From: Mark Warwick [REDACTED]
Sent: 24 October 2019 15:17
To: Michael Eastham [REDACTED]
Cc: Planning.Responses [REDACTED]
Subject: Consultation response: The Boweries, Barnham Road, Eastergate (EG/22/19/OUT - amendment)

Proposal: Outline application with some matters reserved for the erection of 28 No. dwellings, access, landscaping & associated works (re-submission following EG/42/18/OUT).

I comment following submissions received subsequent to my initial response, report dated 22nd May 2019.

client			
Domusea Limited			
project			
The Boweries Barnham Road Eastergate			
title			
Wider Development and Landscape Framework Plan			
date	scale @ A3	drawn	chkd
Jan 2019	1:1500	MRL	GBC
project no.	drawing no.	rev	
1815	1000	P01

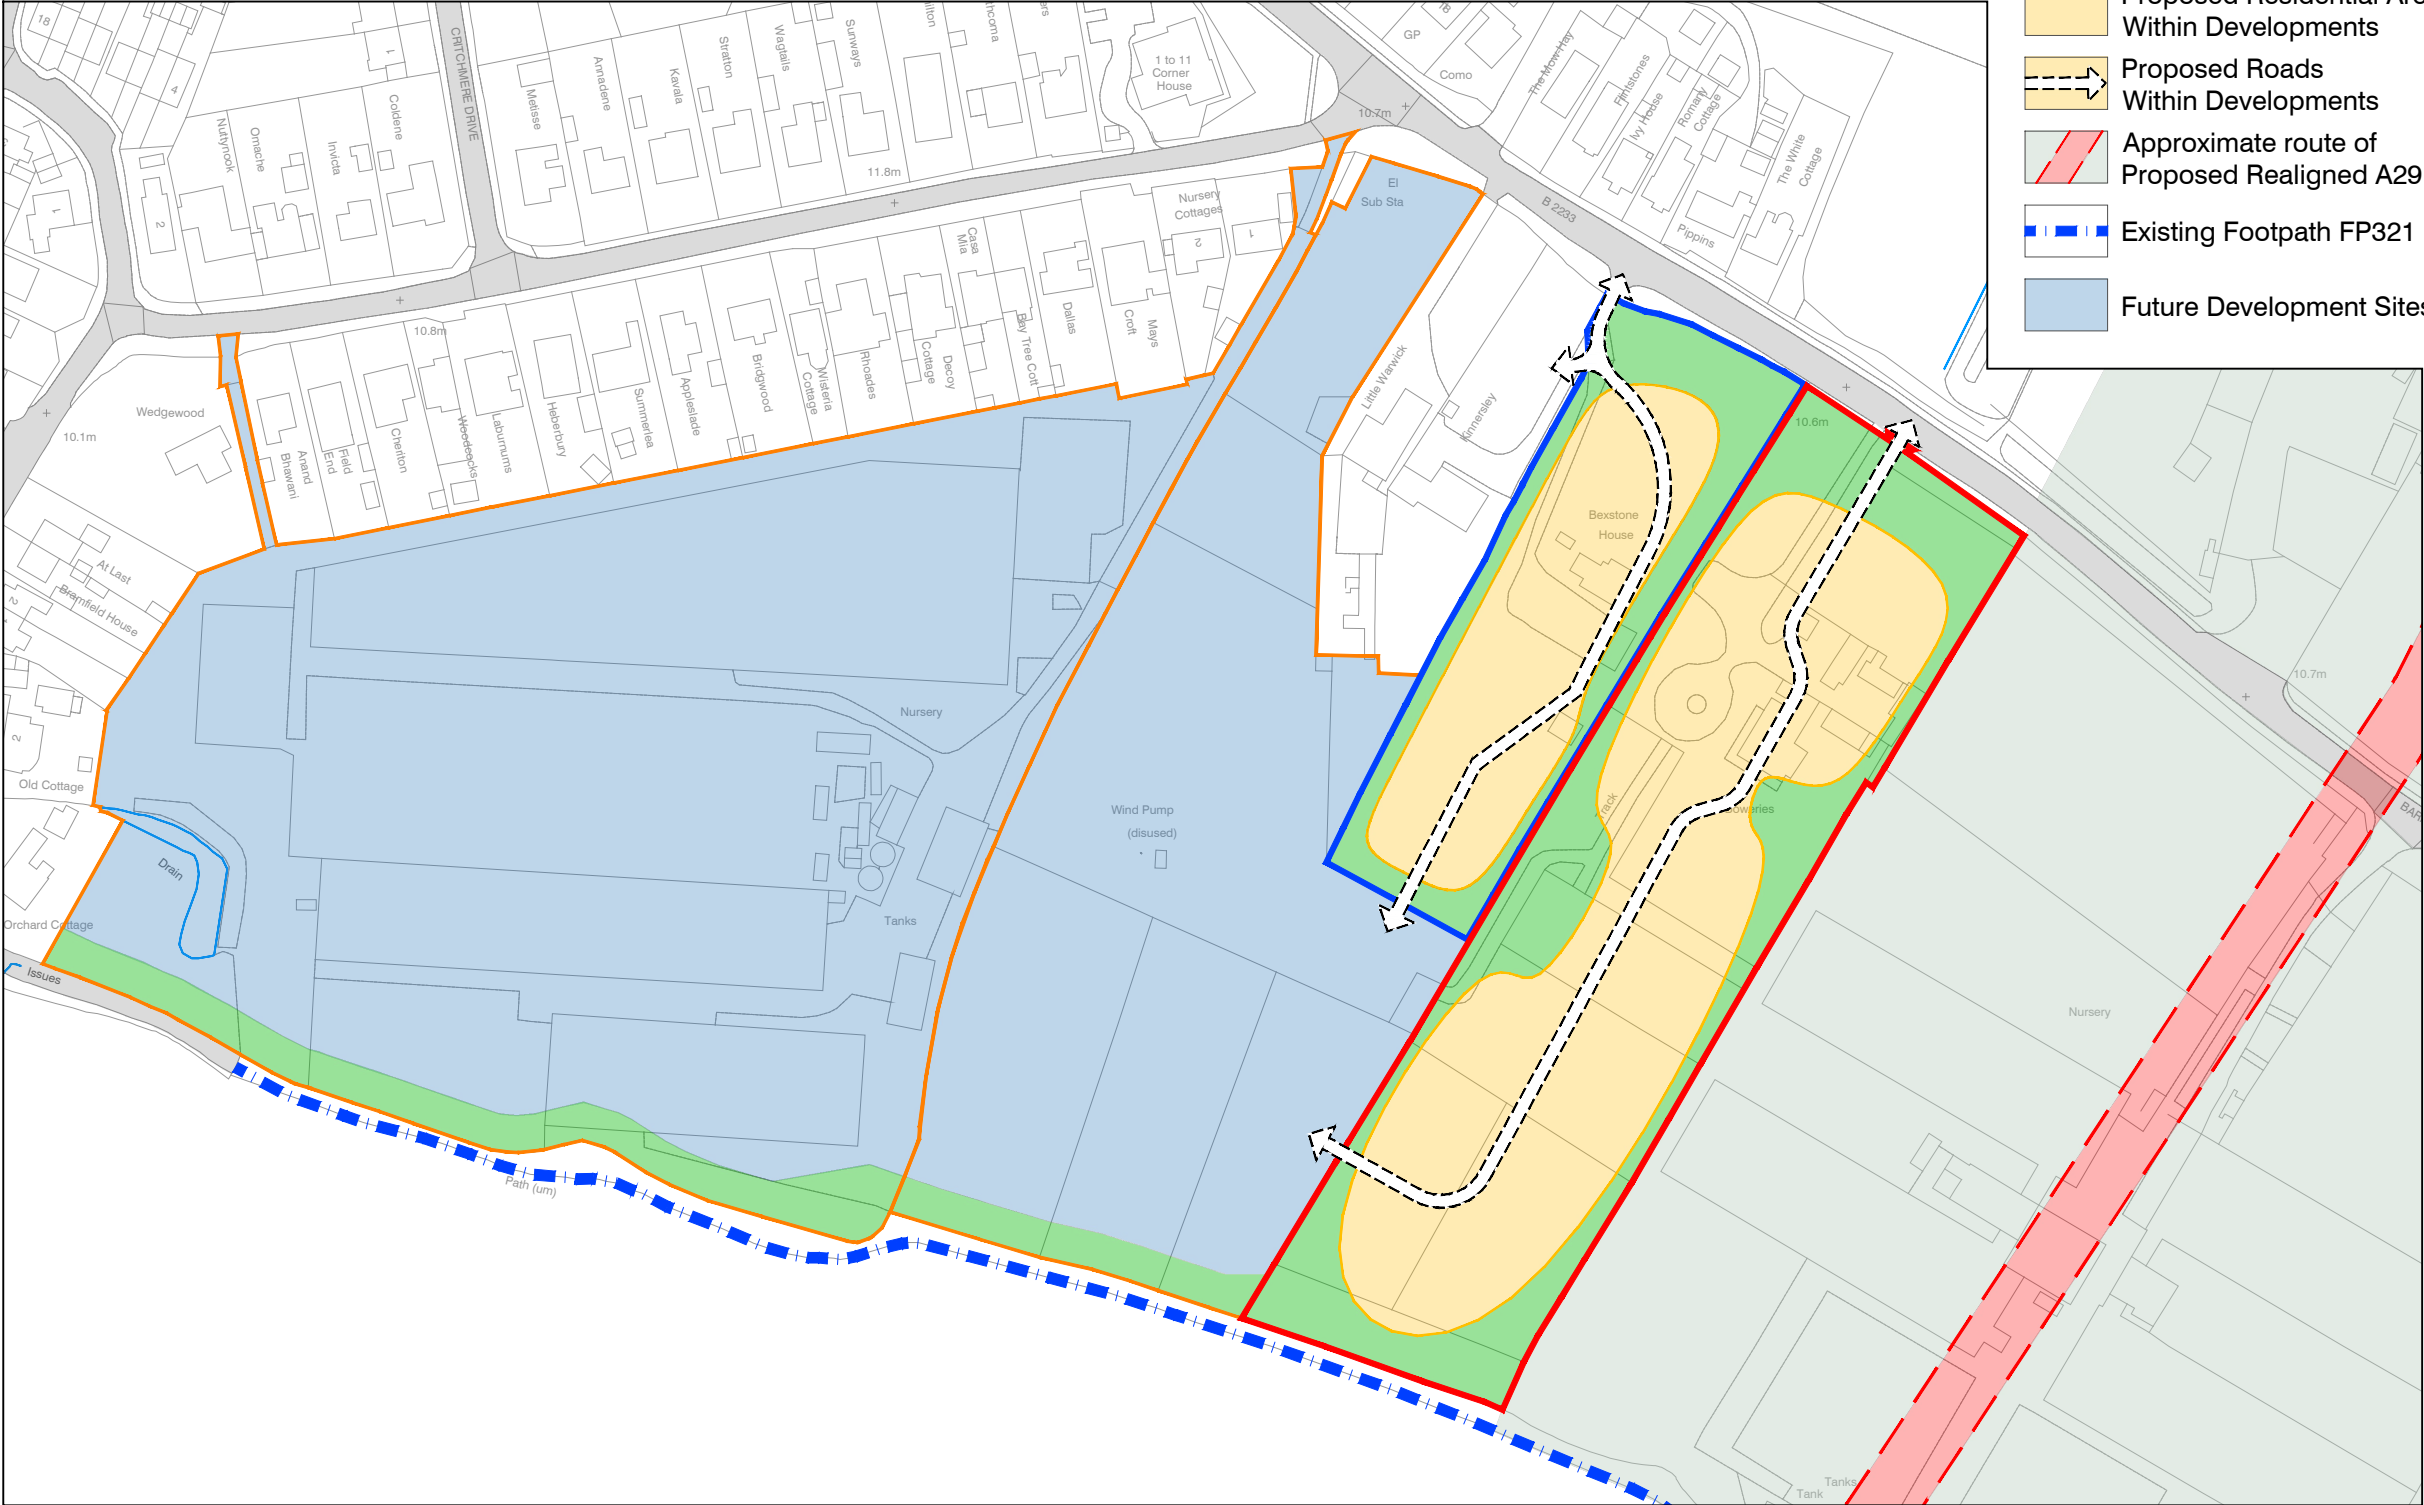
1. Wider Development and Landscape Framework Plan (plan dwg. 1000 rev P04).
2. Proposed site layout (plan dwg. 101 rev P04).

I support the revised access to this site as shown on item 1. This is a very welcome refinement as it better respects high value amenity trees on the site's front boundary.

I see no obvious reason to sustain my OBJECTION now that we have secured the retention of roadside trees of high public amenity value but would draw your attention to the potential impact of losing the aforementioned tree groups (TL07 and TL19) which may provide valuable screening between developments.
